**From:** [Robert Stark](#)  
**To:** [Simon Truong](#)  
**Cc:** [Amy Watson](#); [JustinClark@grocon.com.au](mailto:JustinClark@grocon.com.au); [chriscarolan@grocon.com.au](mailto:chriscarolan@grocon.com.au)  
**Subject:** RE: IMAX  
**Date:** Wednesday, 4 May 2016 10:20:41 AM  
**Attachments:** [image002.png](#)  
[image003.png](#)  
[image004.png](#)  
[image005.png](#)  
[004409\\_HASSELL\\_The\\_Ribbon\\_Hotel\\_Serviced\\_Apartments\\_and\\_Retail\\_Pedestria....pdf](#)  
[Management Plan for Ribbon Hotel - V3.pdf](#)

**From:** [Simon.Truong@planning.nsw.gov.au](mailto:Simon.Truong@planning.nsw.gov.au) [mailto:[Simon.Truong@planning.nsw.gov.au](mailto:Simon.Truong@planning.nsw.gov.au)]  
**Sent:** Tuesday, 3 May 2016 2:31 PM  
**To:** Robert Stark  
**Cc:** [Amy.Watson@planning.nsw.gov.au](mailto:Amy.Watson@planning.nsw.gov.au)  
**Subject:** RE: IMAX

As discussed, following review of the additional information submitted, the Department requires the following:

GROUND FLOOR PROPOSED  
 CLEARANCES TO RMS ROADWAY  
 STRUCTURES

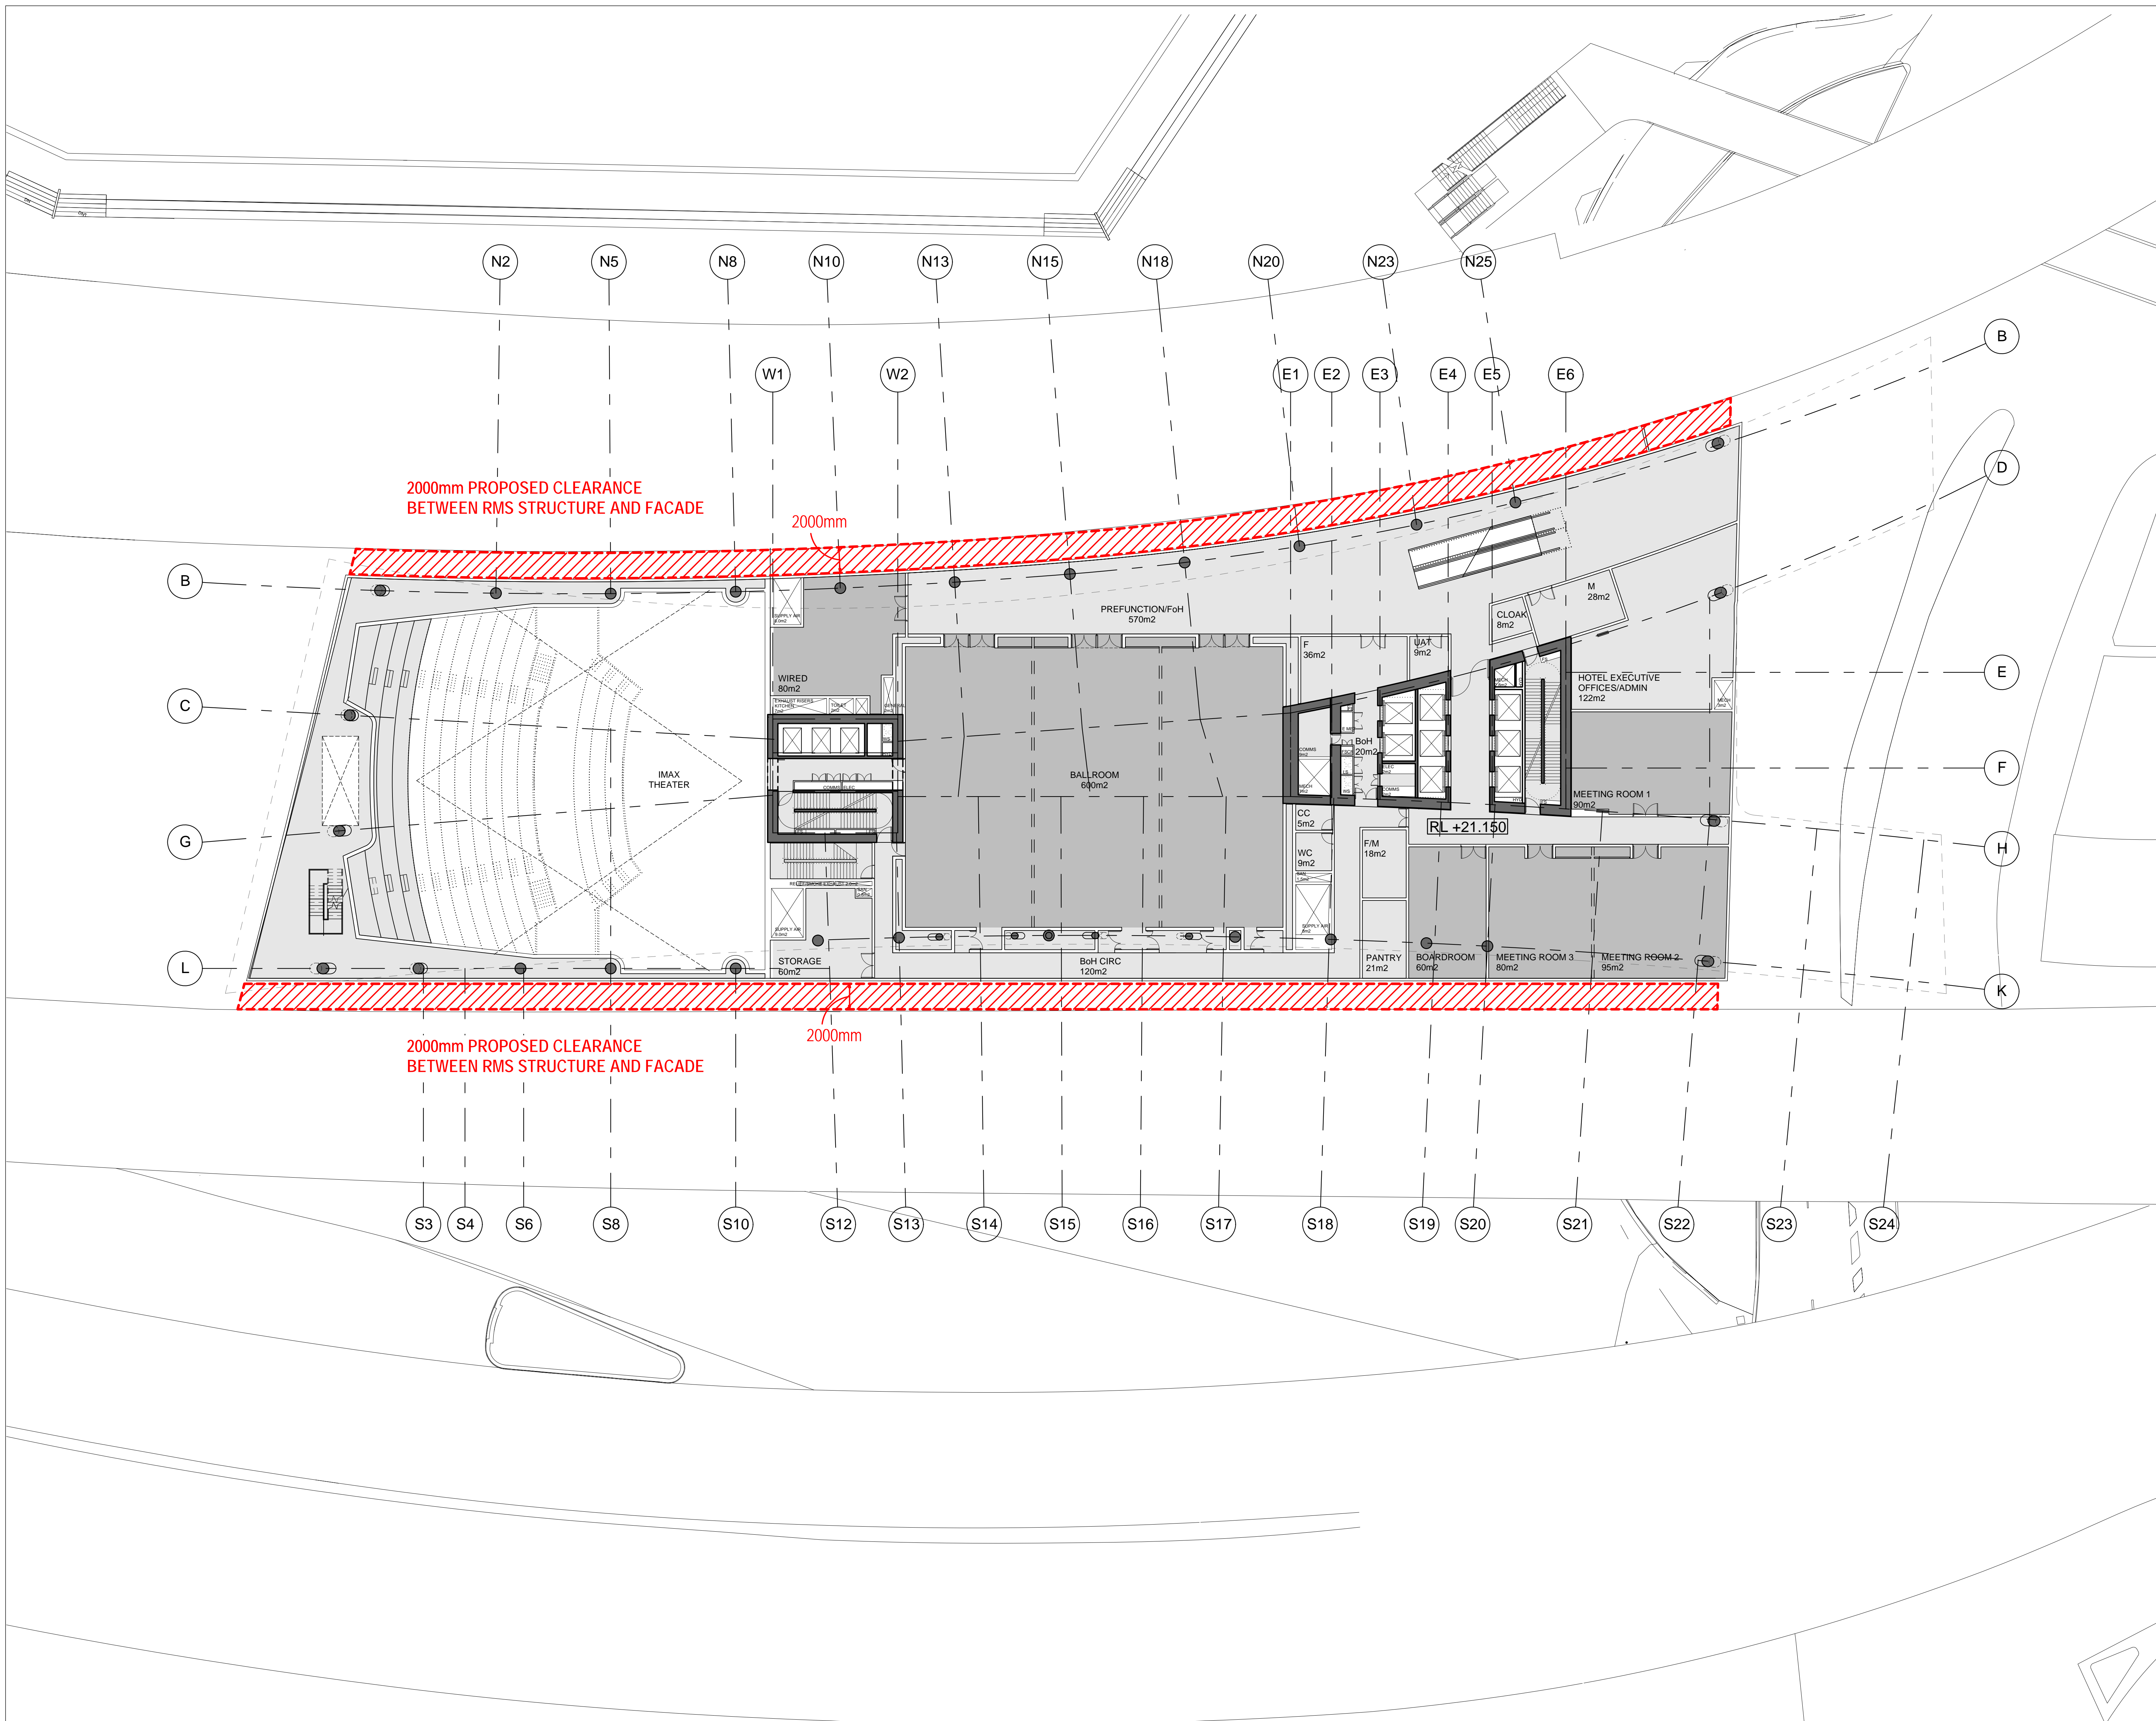
- further justification as to why the proposed two storey foot print for the SHFA building is unable to be realigned with the existing footprint as per the PAC's requirement with the commercial scheme (condition B3);
  - The external outline and internal dimensions proposed for the SHFA building were developed in collaboration with SHFA to create tenancies and a public domain that can attract appropriate and viable tenants, and meaningfully activate the pedestrian pathway. It is important to note that the structure of the roadway above is a significant constraint, providing obstruction in height as well as depth. It is not possible to simply 'push' the SHFA building deeper under the roadway.
    - o Activation of the Public Domain – The alignment and detailing of the SHFA Building have been developed to form a continuous and activated edge to the public domain.

- Building Depth – The depth of the existing SHFA amenities building is inadequate for most retail functions and sits at a level approximately 700mm (3 to 4 steps) below the adjacent ground plane due in part to the clearance requirements below RMS viaduct structure. The outline of the proposed building provides for the minimum depth required by food and beverage retail as well as the same public amenities as the existing building. The clear width of the proposed public domain at its narrowest point is within 750mm of the existing width once the existing steps are taken into account. If the building were reduced in depth to match the alignment of the existing building, the retail spaces would not be viable for food and beverage retail due to the impact of required clearances to existing RMS structure and the opportunity for public domain activation would be lost.

SIGNAGE TYPES AND LOCATIONS
EAST ELEVATION

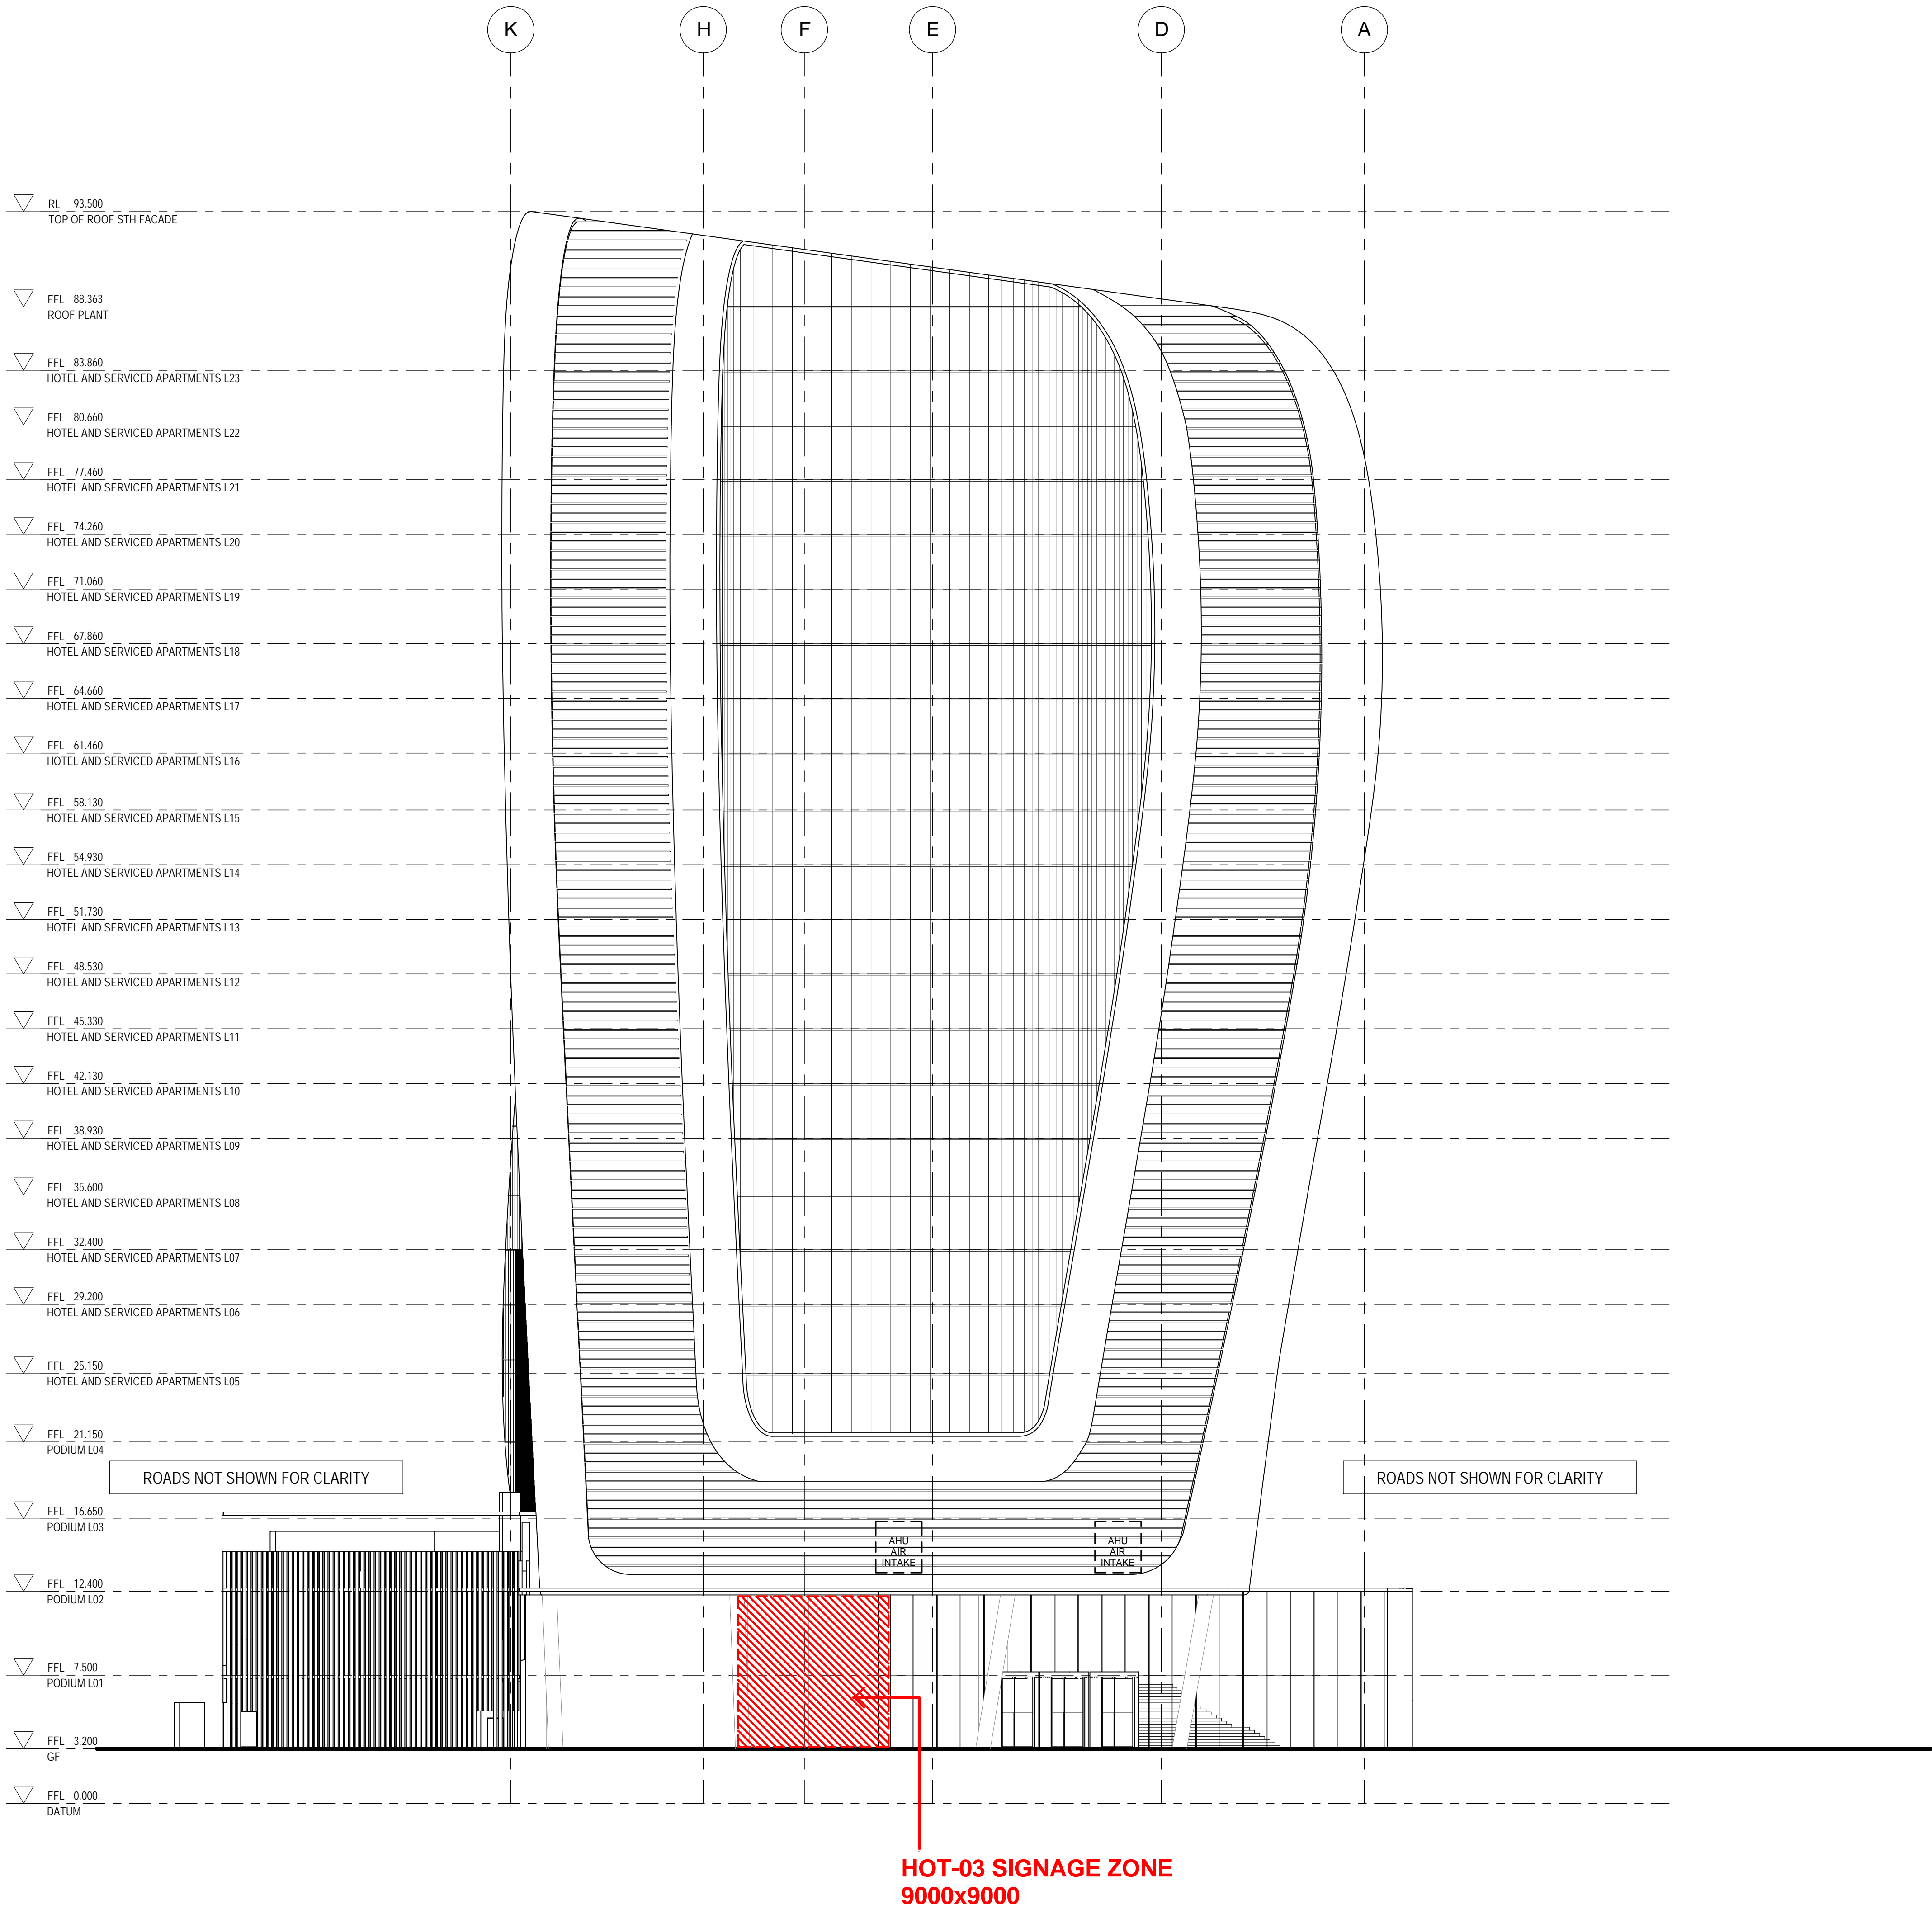
- removal of the term “Discouraging” in point 3 from the plan of management;  
Please see attached amended Plan of Management.
- review and removal of signage zones not originally proposed with the EIS including updated plans with dimensions and details of the future intended purpose; and

Given that the additional IMAX signage was not referred to the RMS, we accept that this should be removed from the proposed development via a condition of consent. This includes signs CIN-01 to CIN-07 identified in the signage package provided with the previous round of additional information. The signage matrix within this information provides dimensions and details of each sign.
